DRB Application No.: 06DRB-01475 (P&F)

Project Name: BANK OF ALBUQUERQUE

**CITY OF ALBUQUERQUE
PLANNING DEPARTMENT
October 18, 2006
DRB Comments**

RE: Lots 15 & 16, Block 9, Tract 2, N.A.A. Unit 3/p&f

1 SITE PLAN FOR BUILDING PERMIT

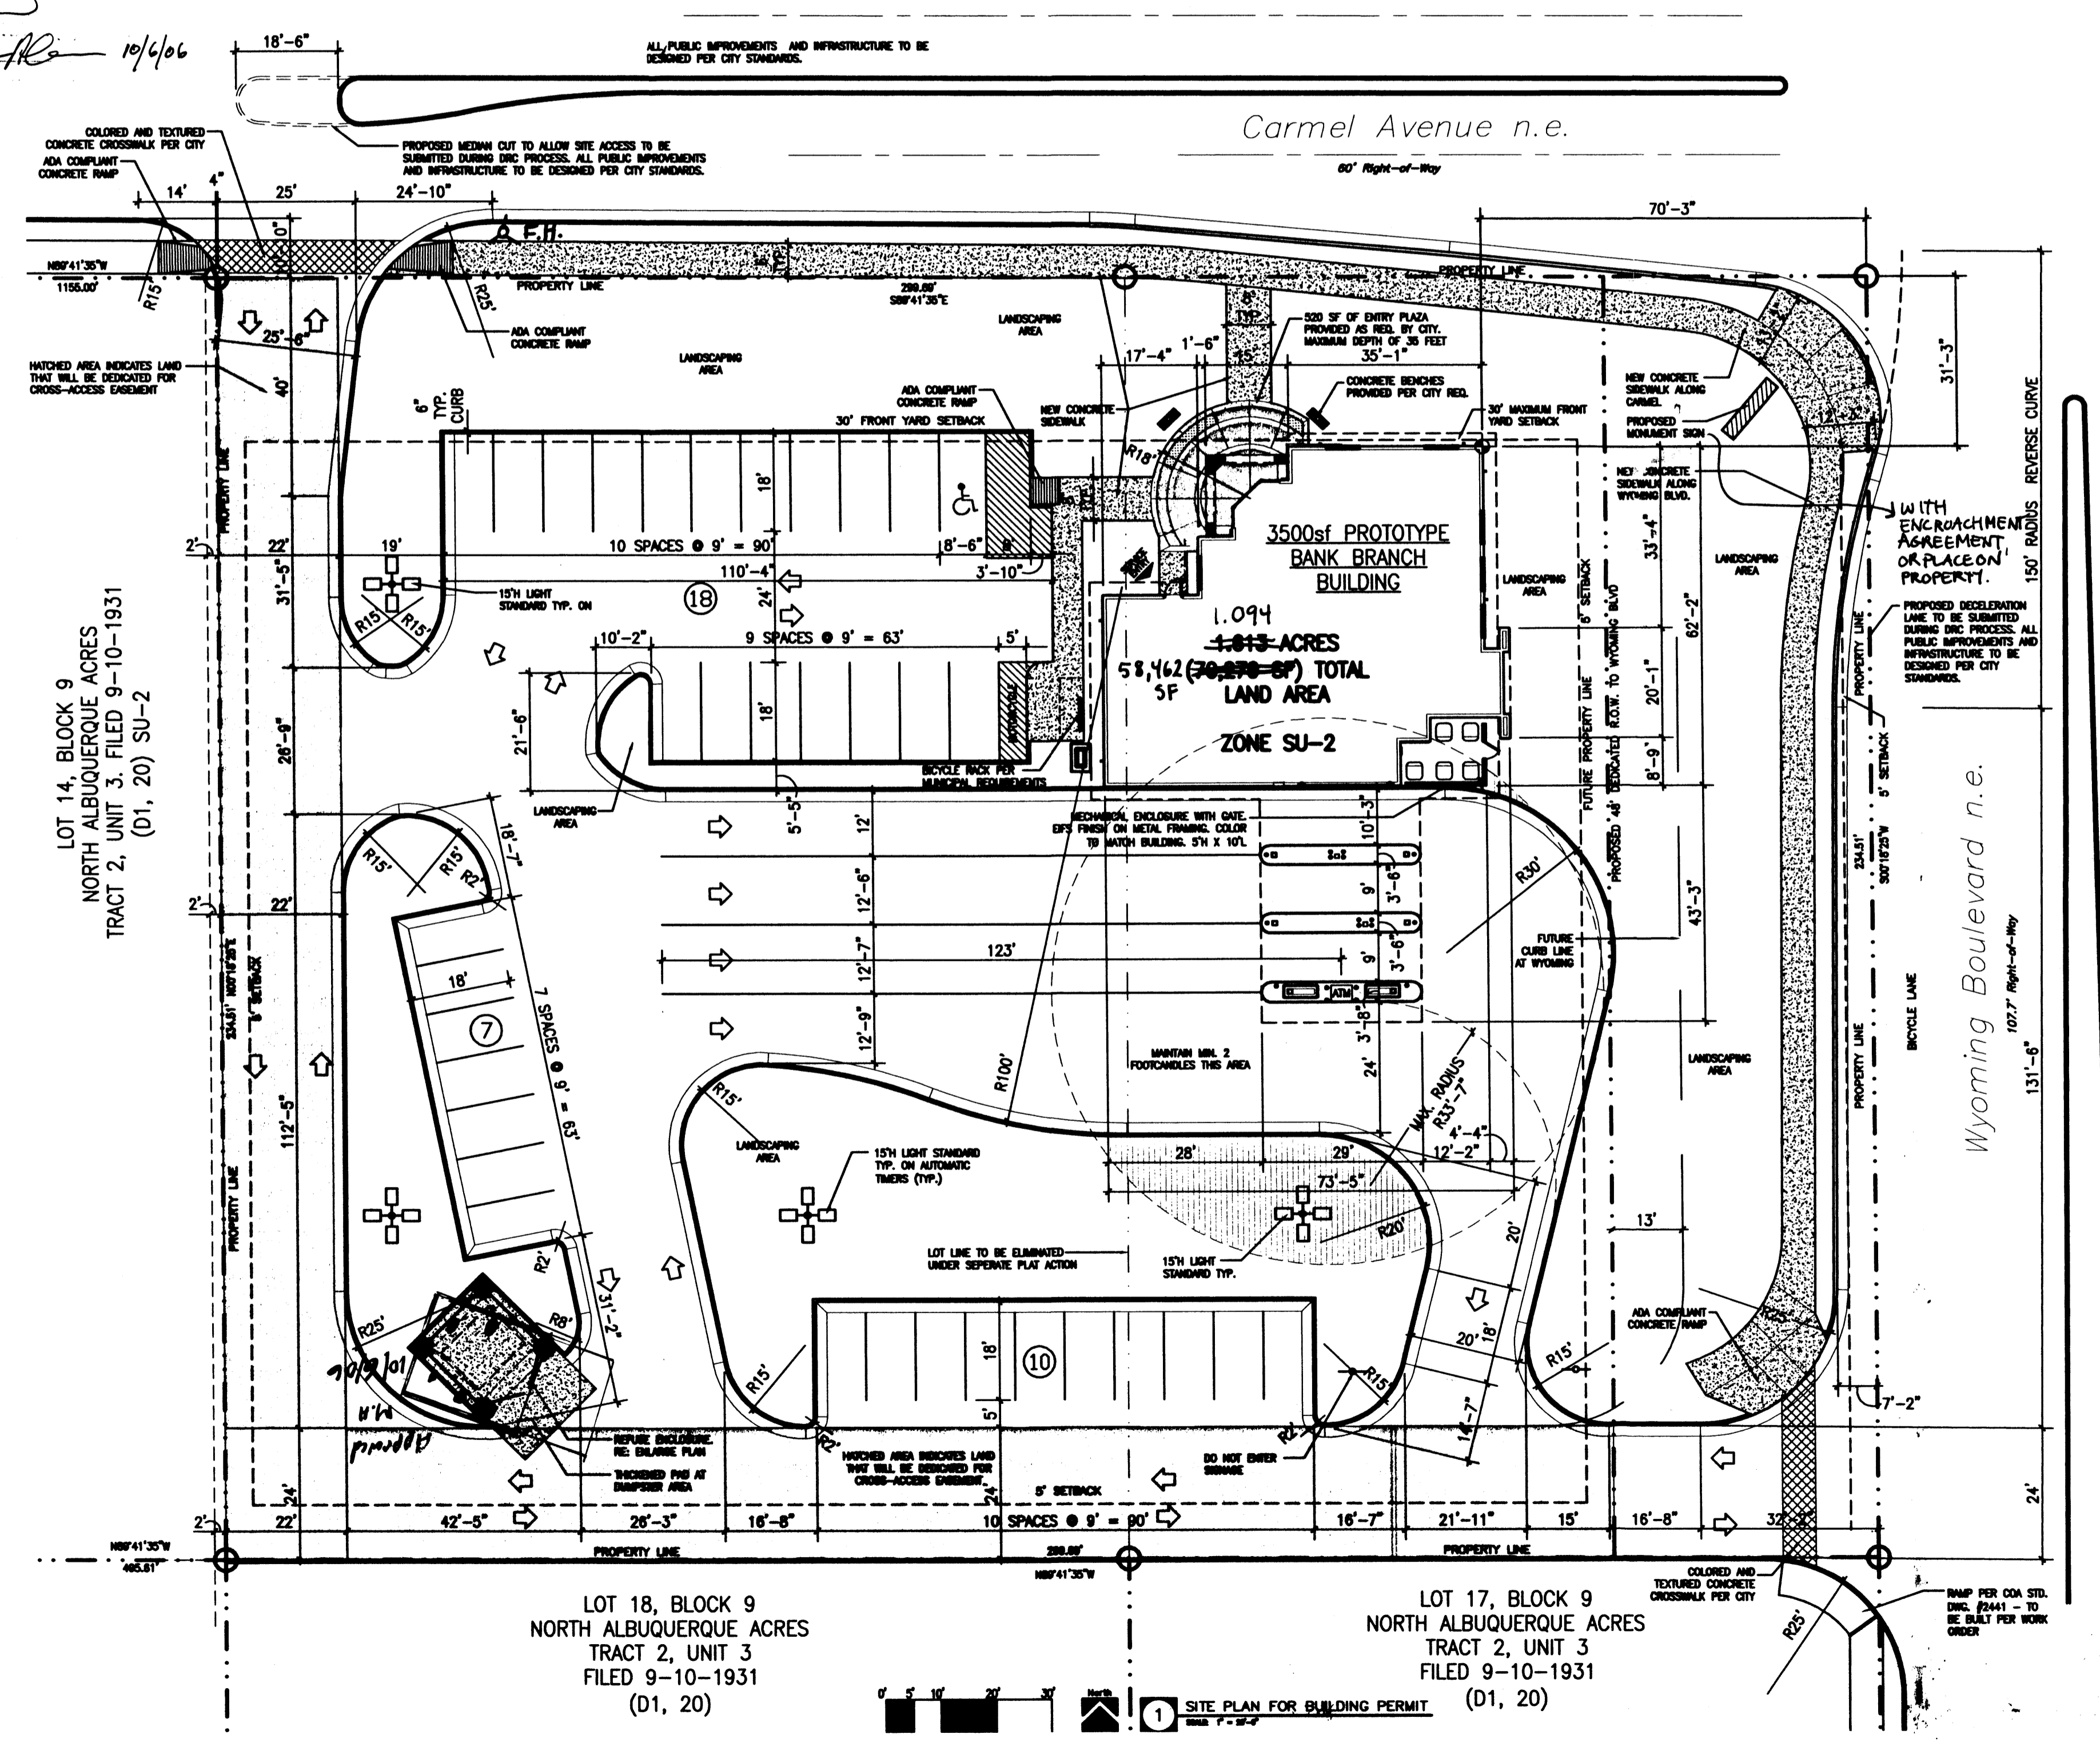
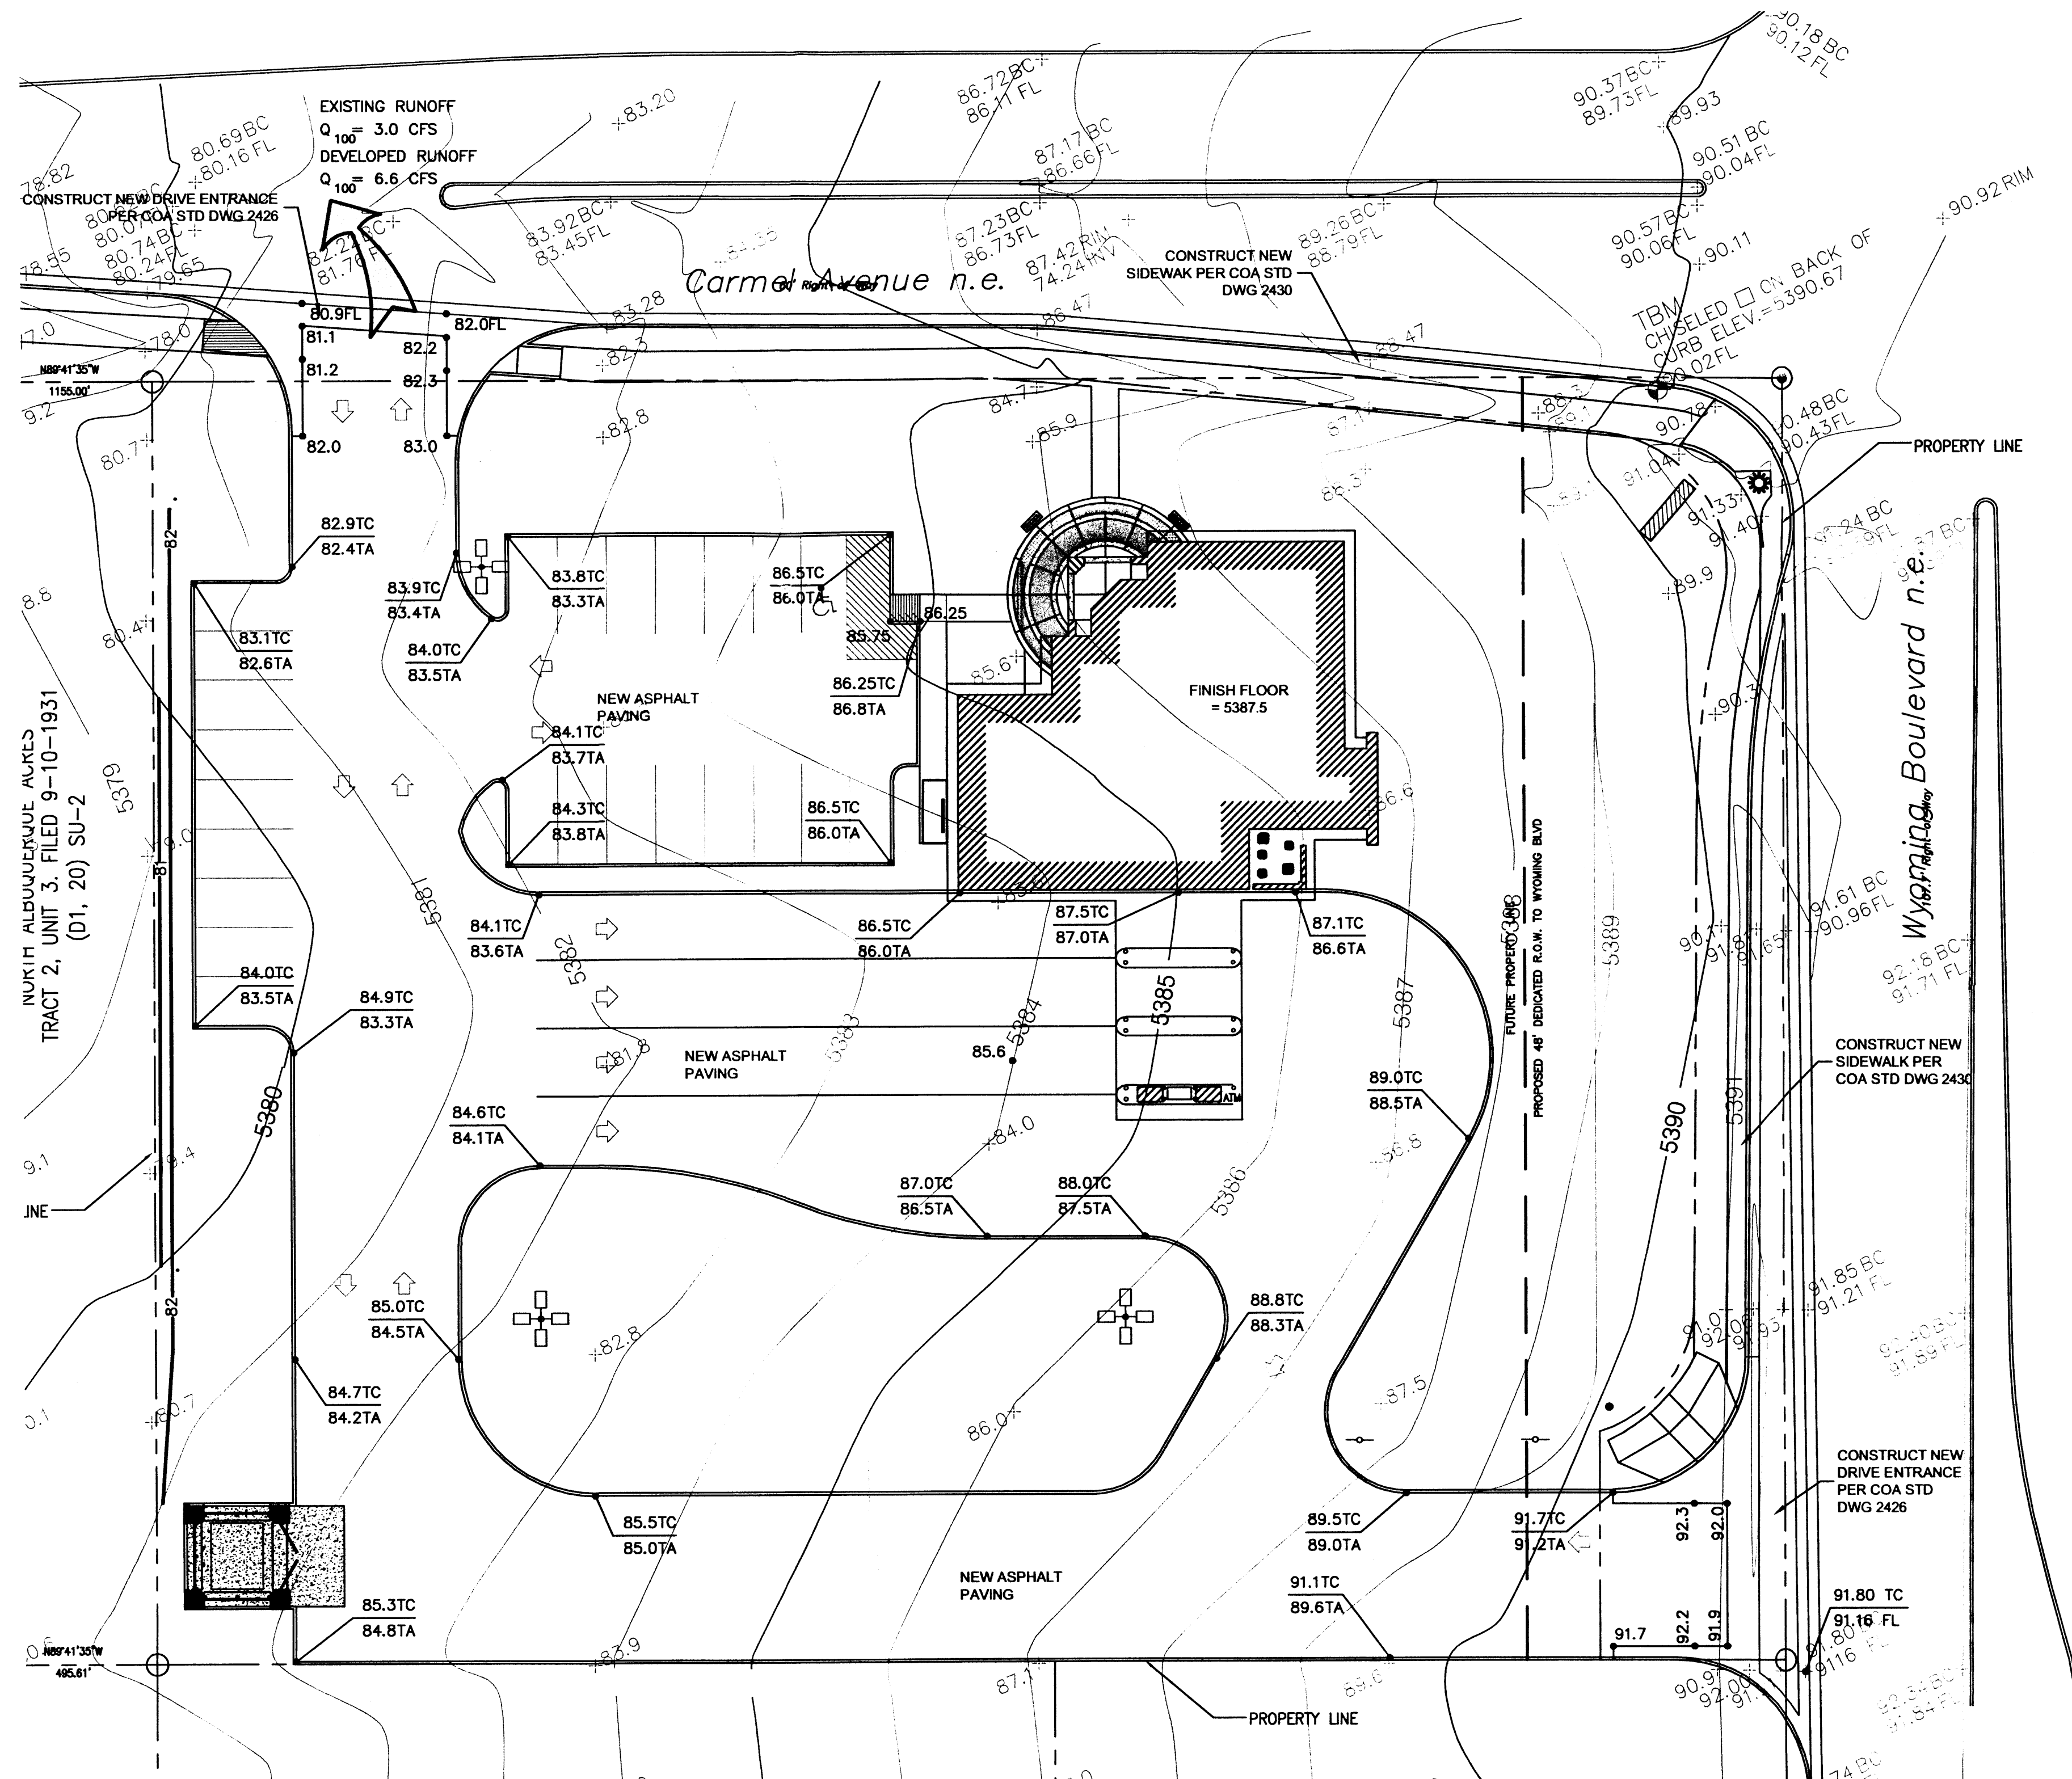
PLANNING (Last to sign): 3 copies
correct drawings to match plan
 AM

APPROVED WITH FINAL SIGN OFF DELEGATED TO CITY ENGINEER FOR SIA AND PLANNING FOR 3 COPIES OF THE SITE PLAN AND CORRECT ACREAGE TO MATCH PLAT.
